Application no: **3/2023/0444**

Address: **Healings Farm West Bradford Road Waddington BB7 3JE**

Proposal: **Prior notification for the demolition of existing workshop building and replacement with one new two-storey dwelling with basement and rooms in the roofspace, including landscaped gardens, access and parking.**

The Local Highway Authority have viewed the plans and highway related documents and have the following comments to make:

Site plan as proposed 1:500 @ A3

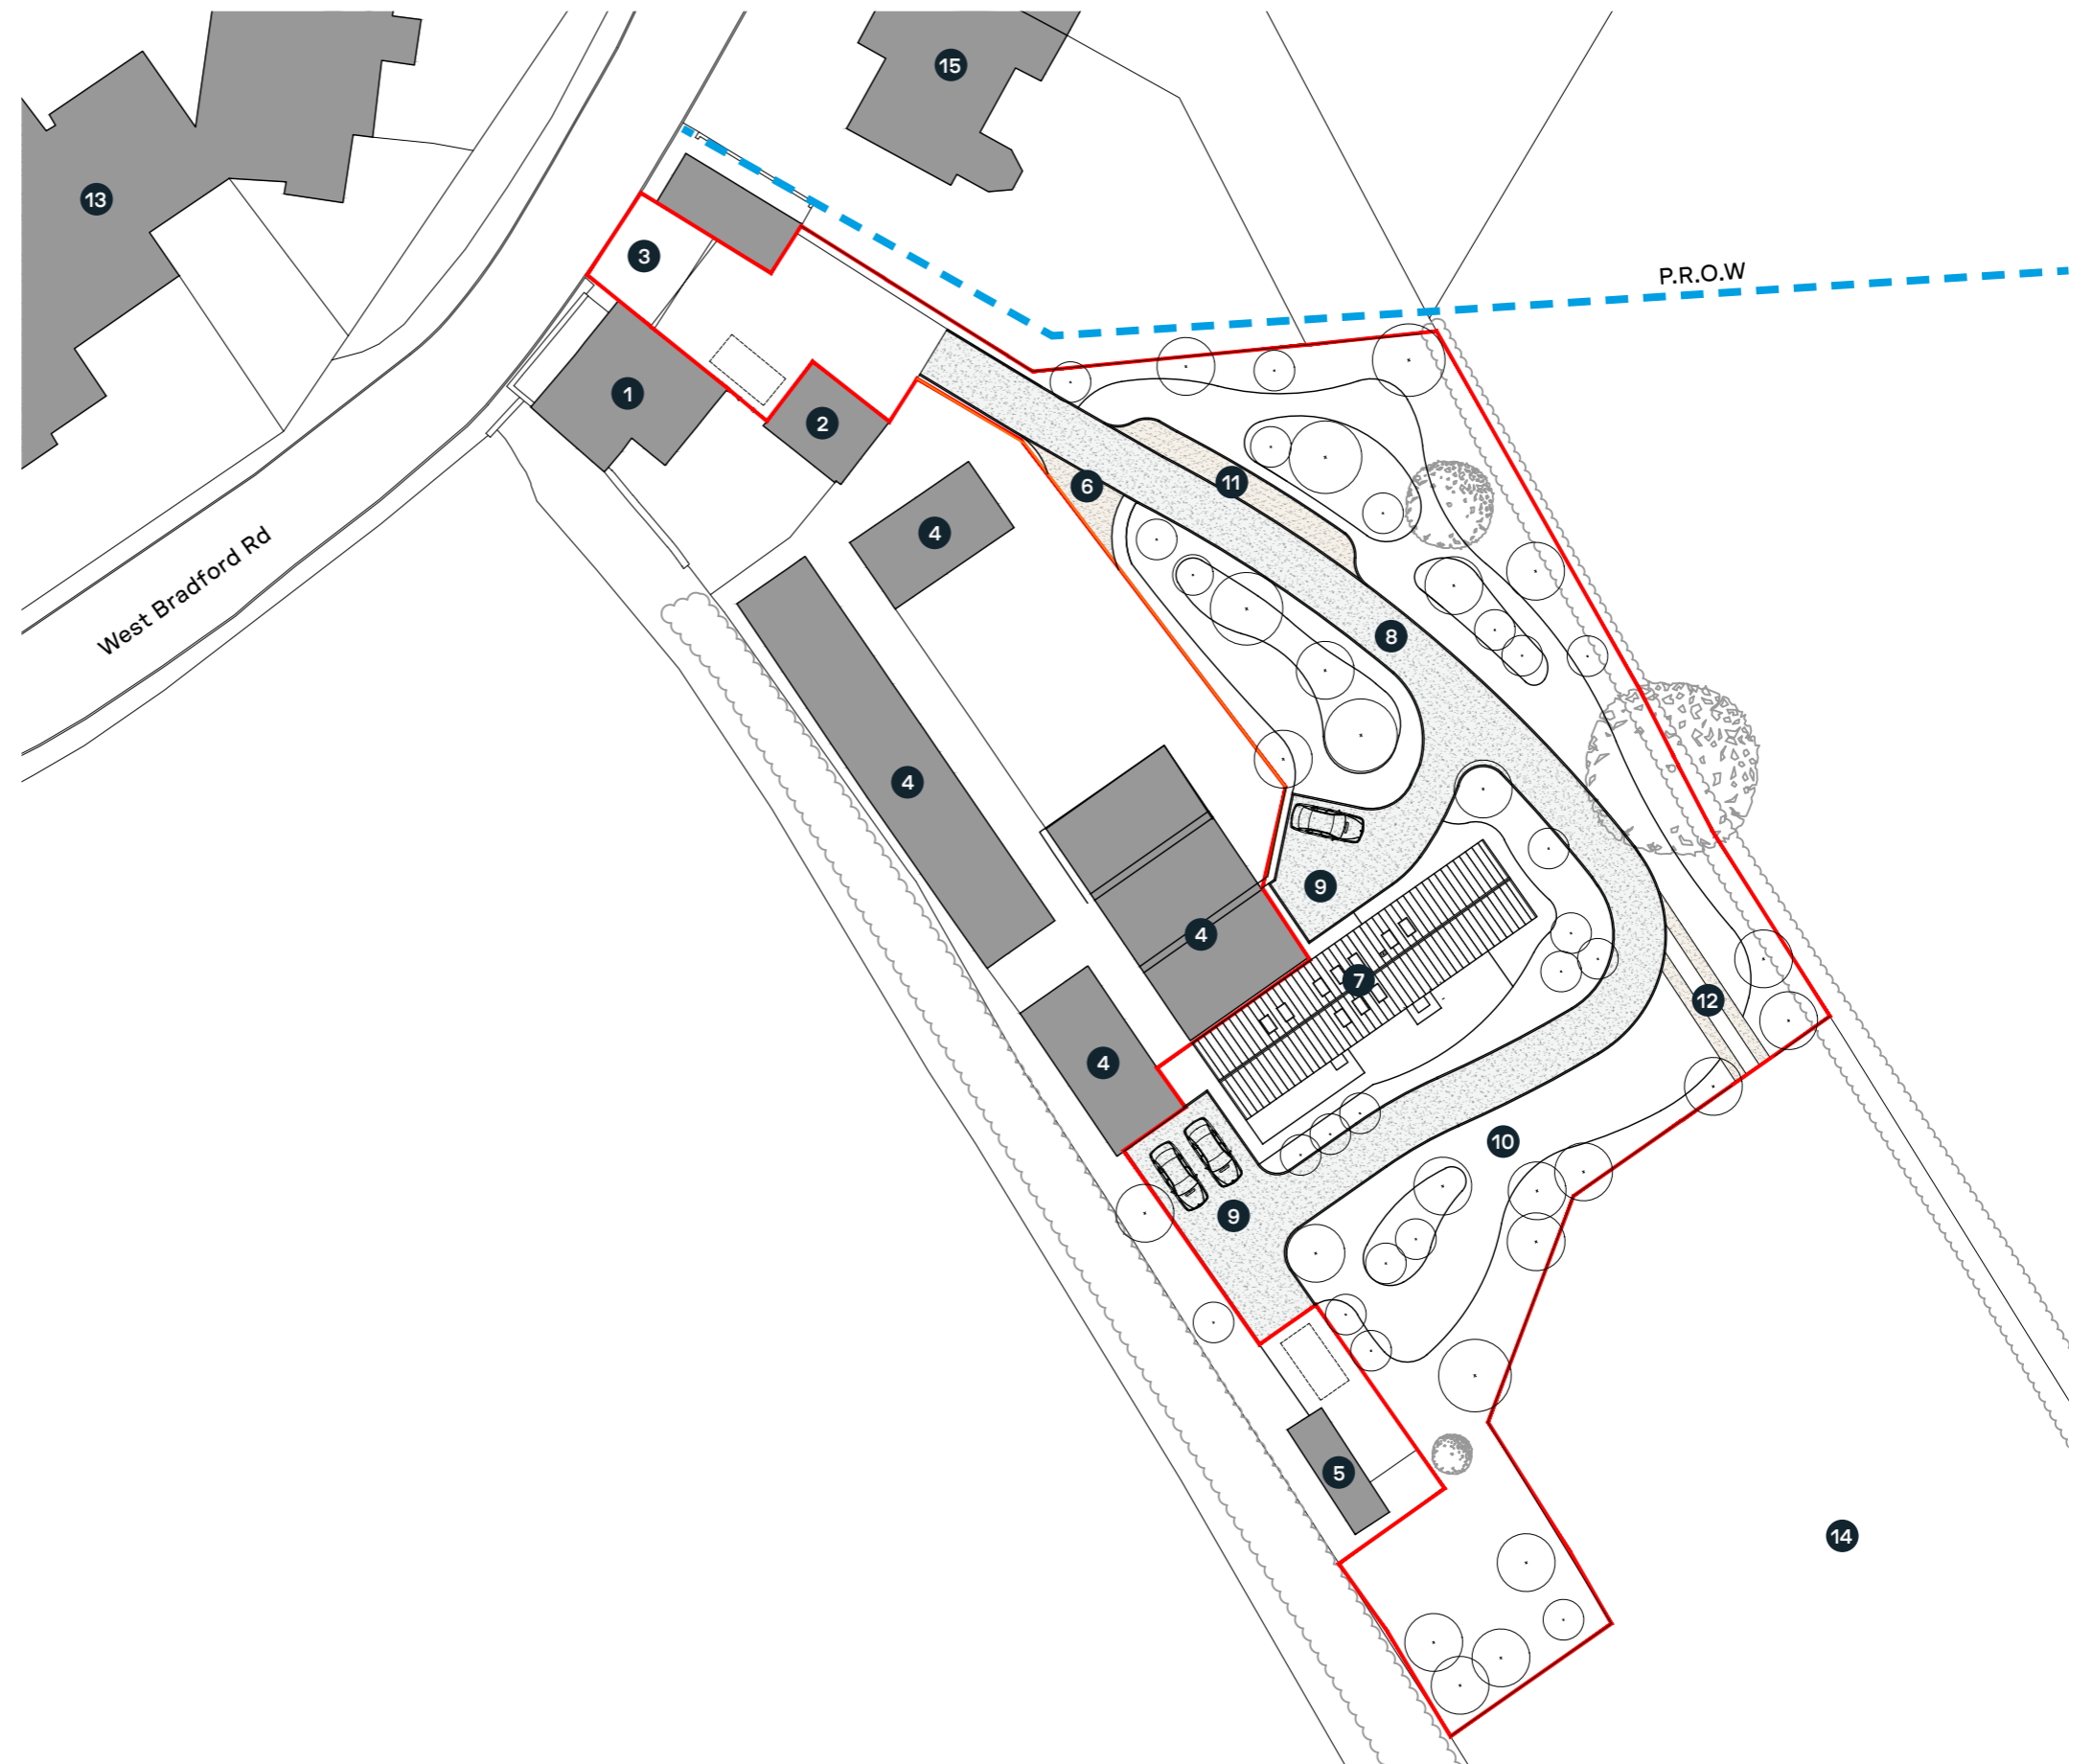
The LHA have reviewed Rural Solutions drawing titled "Site Plan As Proposed Rev A" and are aware that 2 car parking spaces will be provided for the 4 bed dwelling. This does not comply with the LHAs parking guidance as defined in the Joint Lancashire Structure Plan, which requires the dwelling to provide 3 car parking spaces.

However, the LHA will accept the shortfall in parking for the proposed dwelling with the shortfall not having an impact on the adopted highway given that the site is located a significant distance away.

Furthermore, the LHA have reviewed Rural Solutions drawing titled "Site Plan As Proposed Rev A" and are aware that the proposal is aiming to formalise an access track which will serve the site. The proposed access track which connects to the site access and serves the agricultural field, two dwellings (including the one proposed) and a number of buildings which are used for light industrial, will be 3.5m wide which complies with the LHAs guidance. The LHA also welcome the introduction of a passing place along the track.

2. No part of the development hereby permitted shall be occupied until such time as the access and access track arrangements shown on Rural Solutions drawing titled "Site Plan As Proposed Rev A" have been implemented in full.

3. The development hereby permitted shall not be occupied until such time as the parking and turning facilities have been implemented in accordance with Rural Solutions drawing titled "Site Plan As Proposed Rev A". Thereafter the onsite parking provision shall be so maintained in perpetuity.
